**TOWER 2, LEVEL 23
DARLING PARK, 201 SUSSEX ST
SYDNEY NSW 2000**

17 November 2016

S75W (2) AMENDMENT TO MP10_0016 - SCOTTISH HOSPITAL, PADDINGTON

**Option 3** | Infill Planting of *Waterhousia floribunda* and Transplanted Palms With Staged Removal of Selected Weed Trees

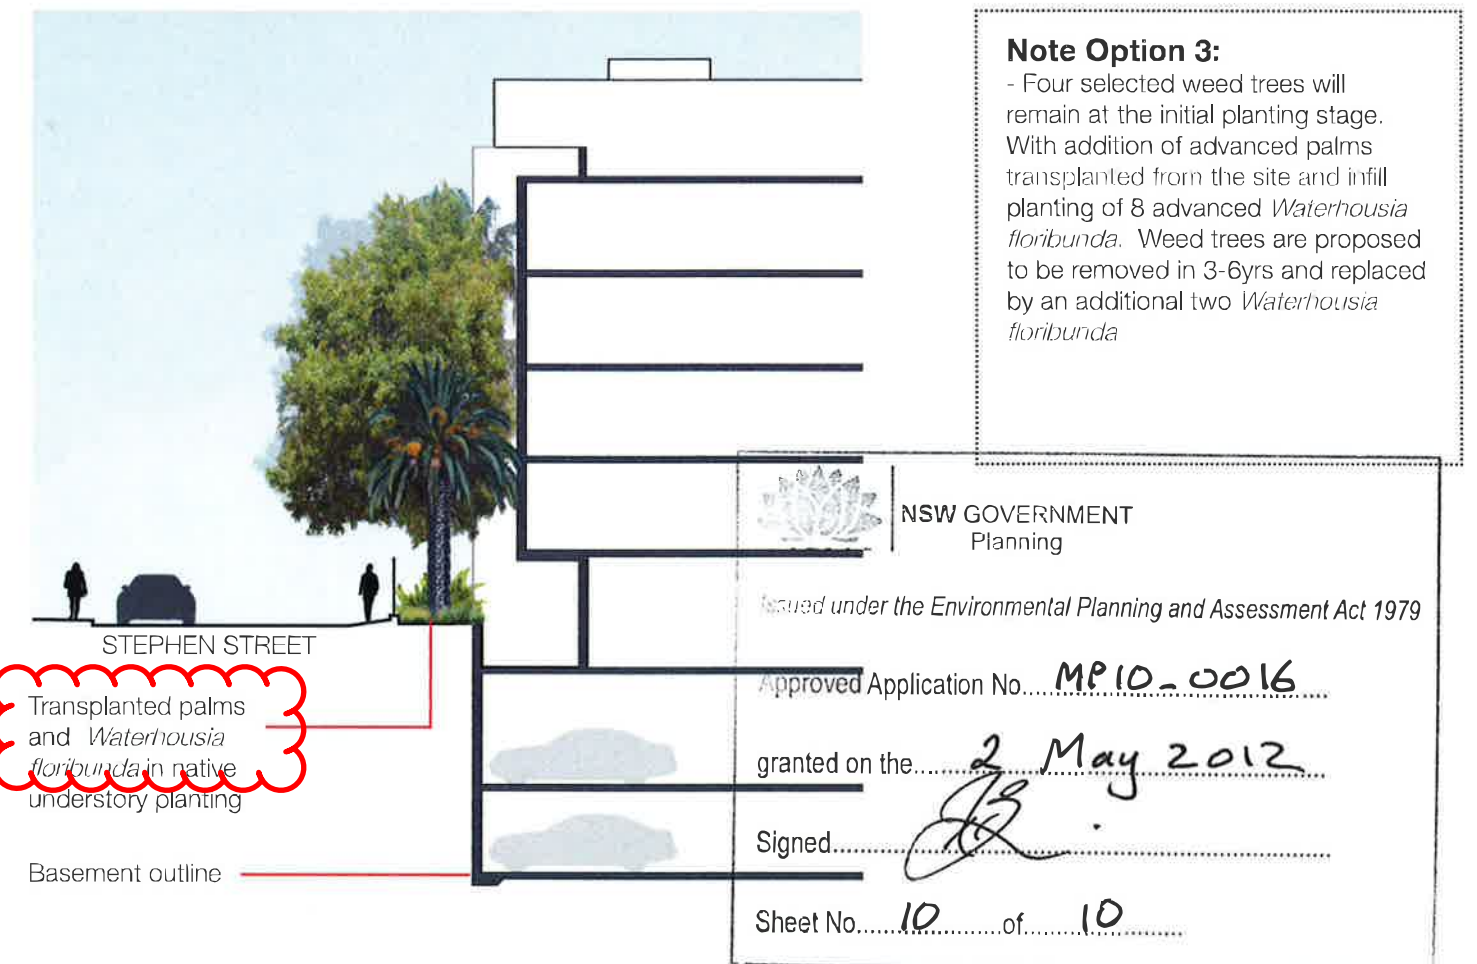
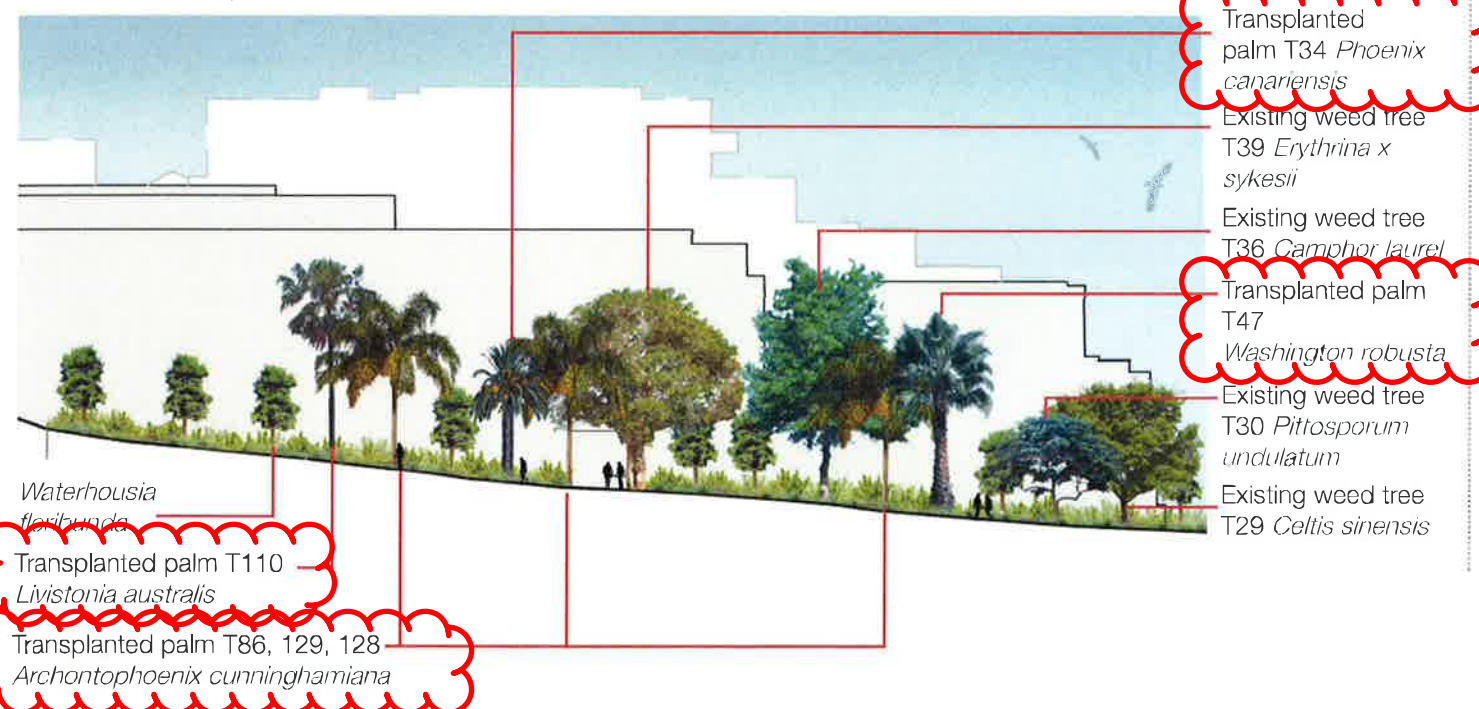
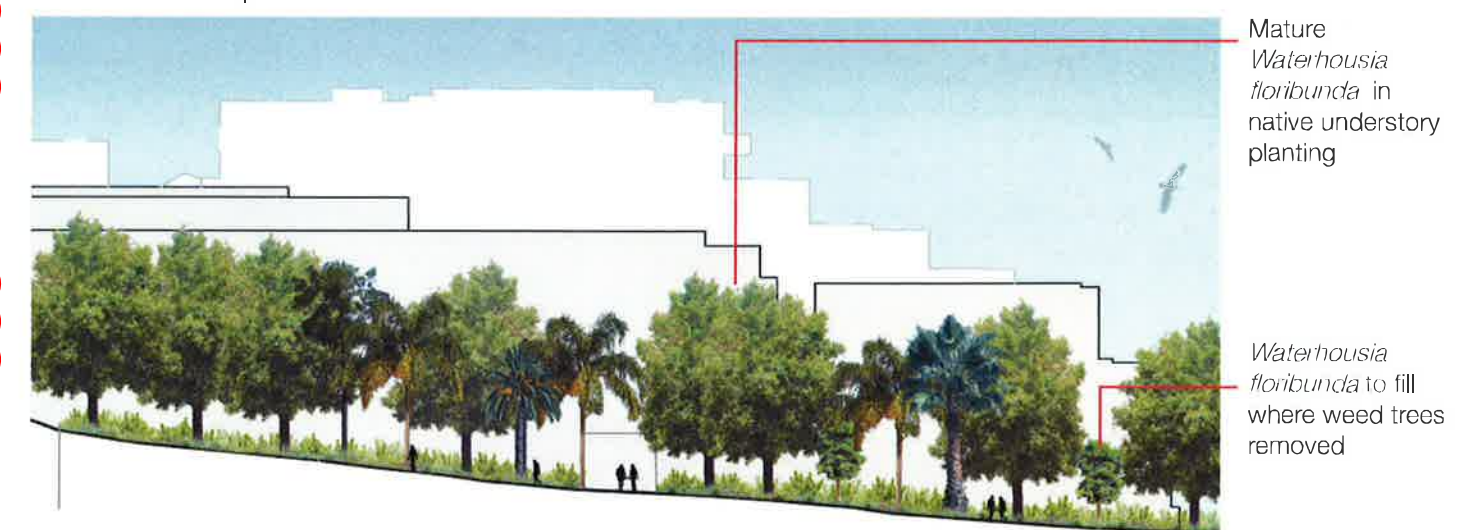
The letter from the Department requested further justification in the form of an Arborists report to support the proposed alternative location for the palms, including justification of why the palms are not proposed on the Stephen Street frontage and consideration of alternative planting on the Stephen Street boundary.

The site palms which were due to be transplanted to locations on the Stephen Street frontage have root balls that are too large to be feasibly installed in the proposed Stephen Street frontage locations. The TWM Transplant Methodology identifies the volume of space needed for site preparation for the transplantation process and the Tree Transplanters Root Zone Letter indicates that the sizes of the palms are too large for installation at this particular location. This is also illustrated in Plan S-PS-1701 Rev P13 which highlights the restricted planter-bed width along Stephen Street.

As a result, nursery sourced palms of the same species are proposed to be planted at these locations, whilst two of these mature palms are to be transplanted to locations further north along Stephen Street adjacent to the retained palm, alongside the public park (i.e. T79 and T120 to be planted alongside T128 - refer to Plan LA-P-1017 Rev 11). This will ensure that the Stephen Street frontage remains well planted and reflects the original project approval.
